2023/0266

Erection of detached double garage to side/front of dwelling

79 Barnsley Road, Dodworth, Barnsley, S75 3JS

SITE / LOCATION PLAN

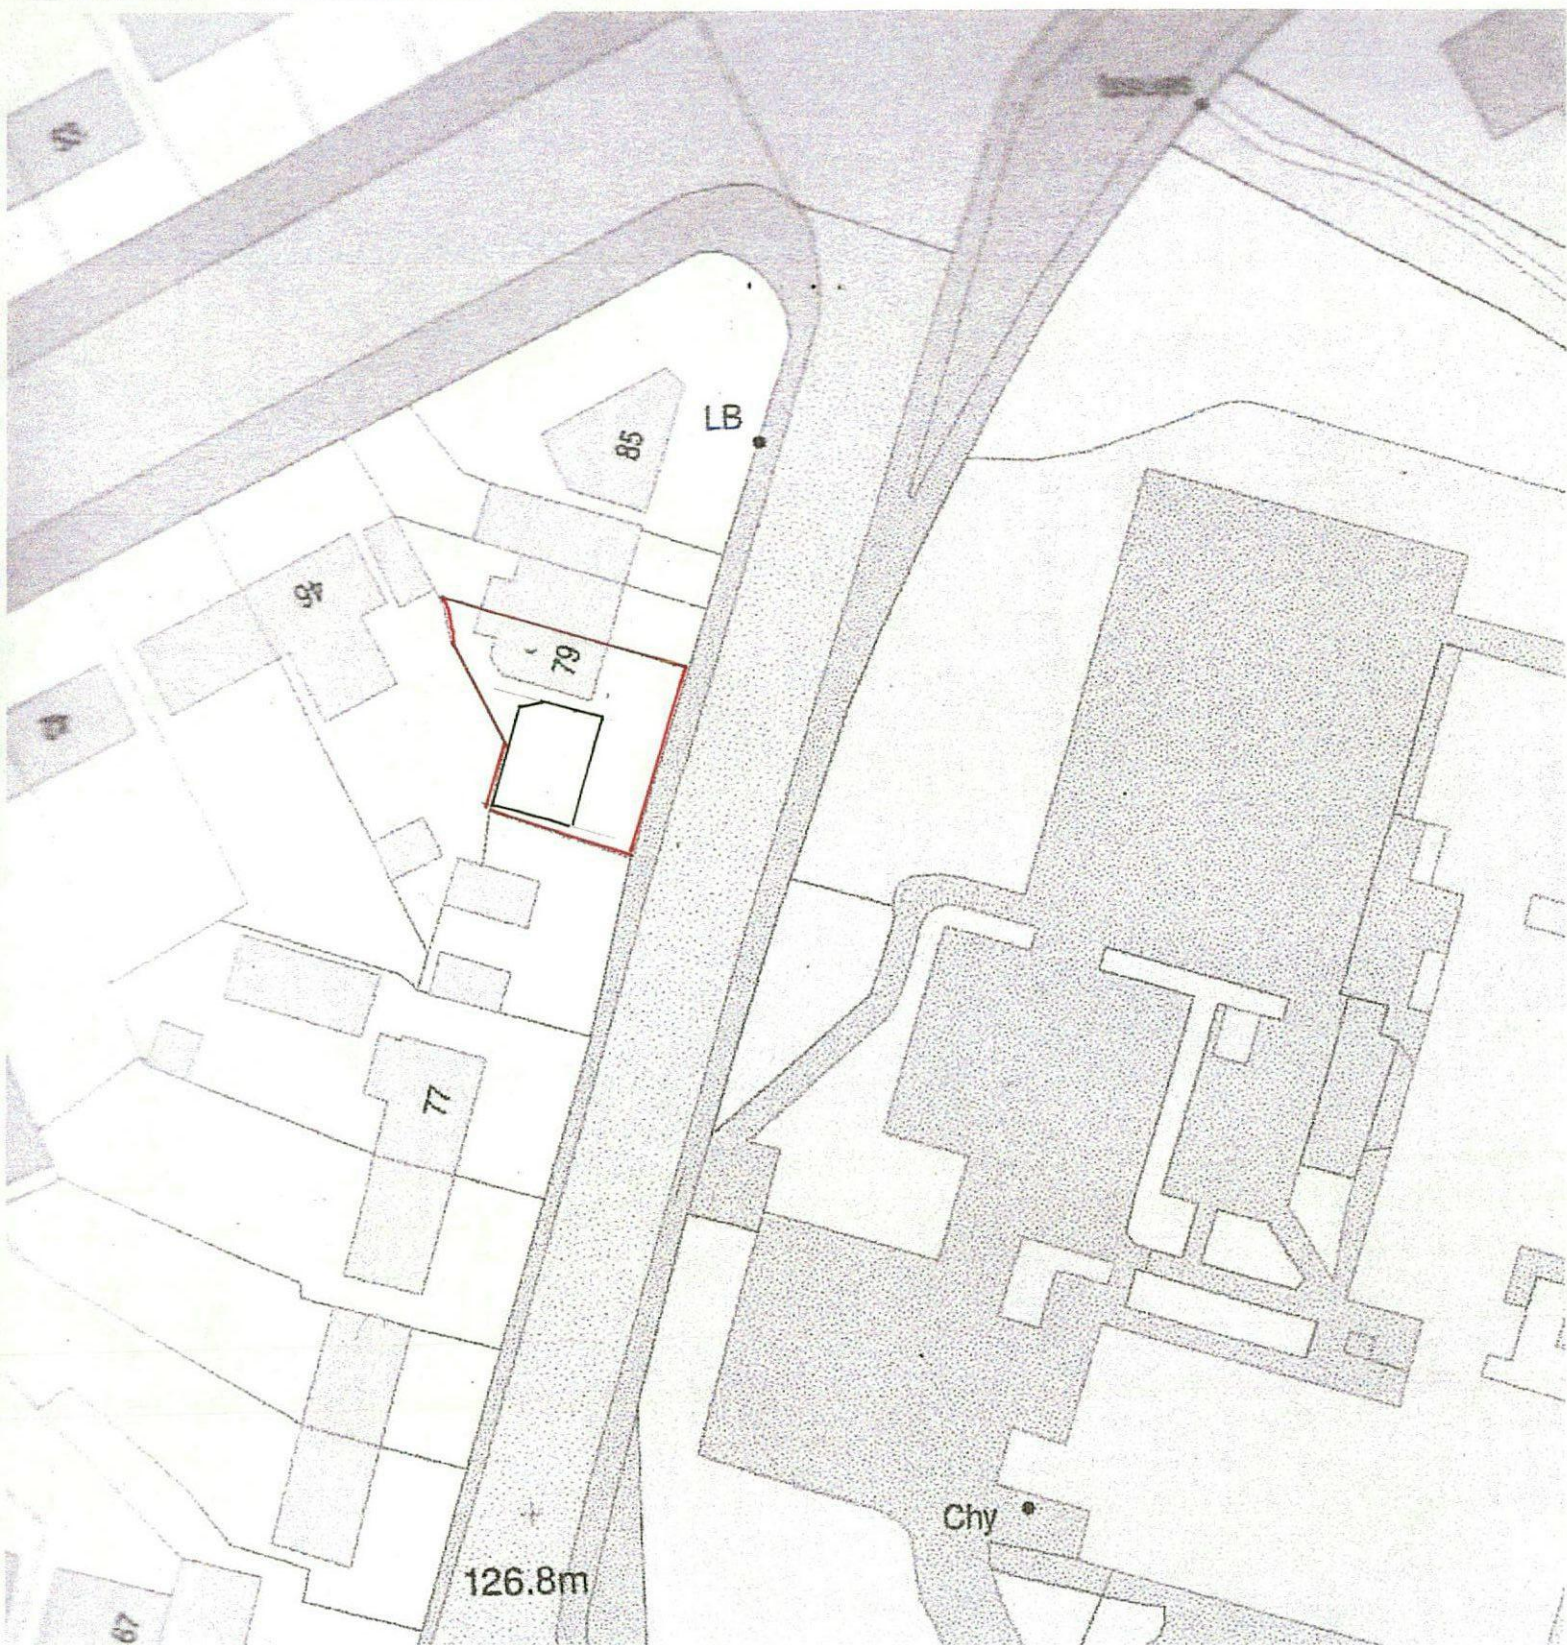
The application site is awkwardly-shaped, with very little rear garden area with no boundary treatment. The proposed garage is located to the Southern side of the dwelling in an area which is utilised for amenity space/parking. Given the awkward shape of the curtilage area, the proposed rear elevation of the garage is positioned on what forms a section of the rear boundary line of the property. The rear elevation would therefore be in close proximity to a neighbouring property (no. 46 Mitchelson Avenue) which shares a boundary line with the said neighbouring property. The proposed rear elevation of the garage is located 10m from the nearest window of no. 46 Mitchelson Avenue which is less than the minimum 12m separation distance expected between habitable room windows and blank gable walls. It is unclear as to whether the neighbouring window is indeed habitable, but this serves a ground floor extension and therefore it is very likely that this serves a habitable room. In any case, the only outlook from the rear elevation and garden area of the neighbouring property is through the existing gap that is located between the side elevation of the dwelling and the neighbouring flats (nos. 77a and 77b Barnsley Road) to the South. The presence and positioning of the garage would clearly obstruct this outlook and lead to a much greater sense of enclosure for the neighbouring property to the rear of the site. Further, the garage is positioned to the South-East of

Additionally, the proposed garage has a footprint size of 46.5sqm which takes up 32% of the available/undeveloped space within the entire site, or 43% of available space in the side/rear garden area (i.e. not ahead of the front elevation of the dwelling). The SPD for House Extensions (section 7.8) states that extensions and outbuildings should not take up a disproportionate amount of private rear garden space with the general principle being that over half of the amenity space should be retained. The garage is to be located to the side of the existing dwelling so the rear garden area is not being affected, however the general principle is that the dwelling retains a suitable amount of undeveloped area within the site to ensure a good standard of living for existing and future residents. The garage will be positioned in a section of the site which clearly served as the primary amenity space for the site, which has already been significantly reduced/disrupted by the presence of hard surfacing and formation of a parking area. This is visible through comparison of Street View Images through the years with the 2011 and 2016 images showing that the side garden was solely used as amenity space before the parking space was formed. Still, the existing situation shows a mixed side garden area with a parking area and graveled area used for sitting. The graveled area will be removed to make way for the development which effectively results in the amenity space on site being significantly reduced to the bare minimum. In the opinion of the Local Planning Authority, the resultant undeveloped space on site would not be large enough to allow for suitable, healthy or attractive amenity space on site which would have a detrimental impact on residential amenity. This is in conflict with the SPD for House Extensions and Local Plan Policy GD1 in that the development does not protect or enhance the living standards of the existing and future residents.

SCALE 1:50 DRAWING No HED/813/22/a DRAWN BY

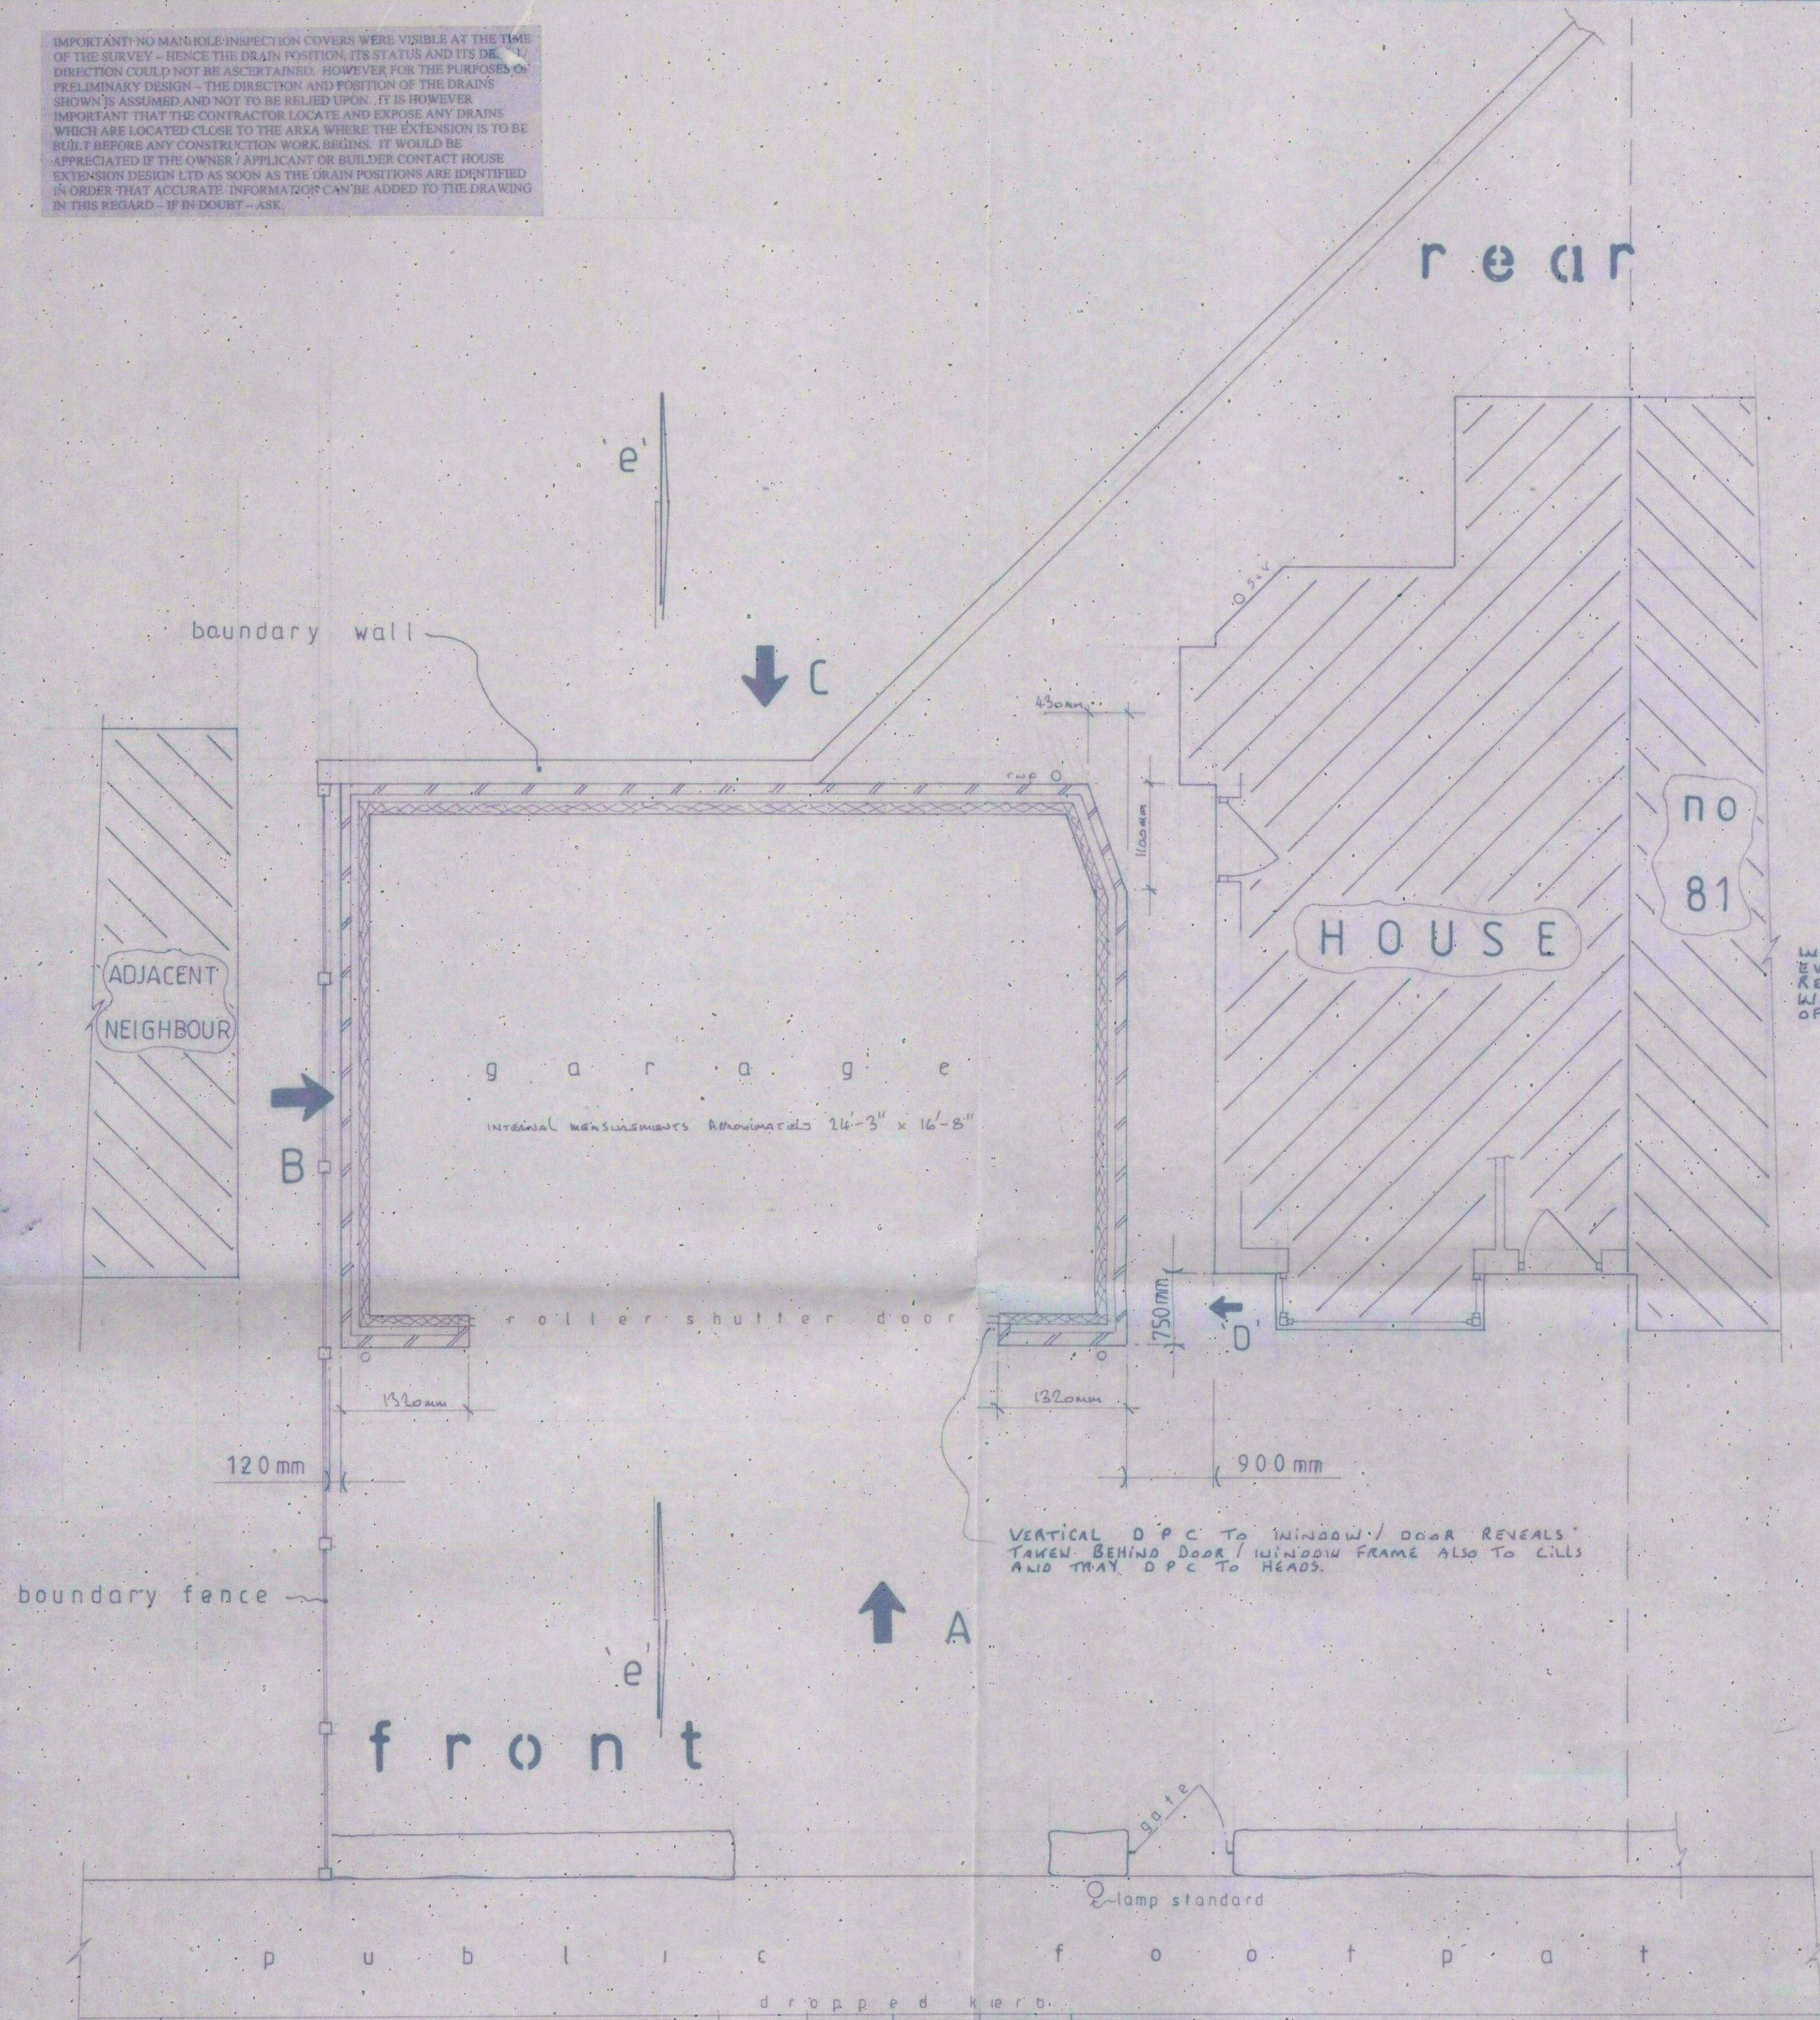
The proposed garage is considered to be largescale for a modestly sized two-bed property on what is a fairly small curtilage area. The proposed width of the garage (8.05m) is almost double the width of the existing dwelling (4.25m) and the proposed footprint (46.5sqm) is larger than the host dwelling (35.5sqm). It is appreciated that the proposed garage is single storey but the overall size and scale is not considered to be in line with the SPD in that it is not sympathetically sized compared to the existing dwelling. The garage is located in a very visible location both within the site, and in the street scene – on a main road, as well as the garage being set slightly forward (750mm) of the front elevation of the dwelling. When constructed, it will be form an excessively sized and visually incongruous feature within the street scene.

The proposed development is contrary to the Council's SPD for House Extensions, Local Plan Policy D1 and NPPF paragraph 134 in that it is of an unsympathetic size compared to the host dwelling, with a much larger width, larger footprint and featuring an unsuitable flat roof style which does not match or relate successfully to the host dwelling. Given that the garage will be visible and prominent from the street, slightly set forward of the host dwelling's front elevation and will form an intrusive and unattractive building within the street scene, not having a positive impact on the visual amenity of the local area. The proposed development is therefore considered to be unacceptable in terms of visual amenity.

no. 46 and will lead to a significant overshadowing impact, especially at earlier points in the day. The proposed development is therefore contrary to Local Plan Policy D1 and the SPD for House Extensions in that it does not protect the amenity enjoyed by the existing and future residents of the area.

The proposed garage does not meet the minimum internal space standards expected for garages to be considered a parking space, as it falls short on the internal length. The minimum internal length of a garage should be 6m with the proposed garage being 5.15m. Further, there should be a 5.5m separation between a roller shutter door on a domestic garage and the highway, which is not met in this case.
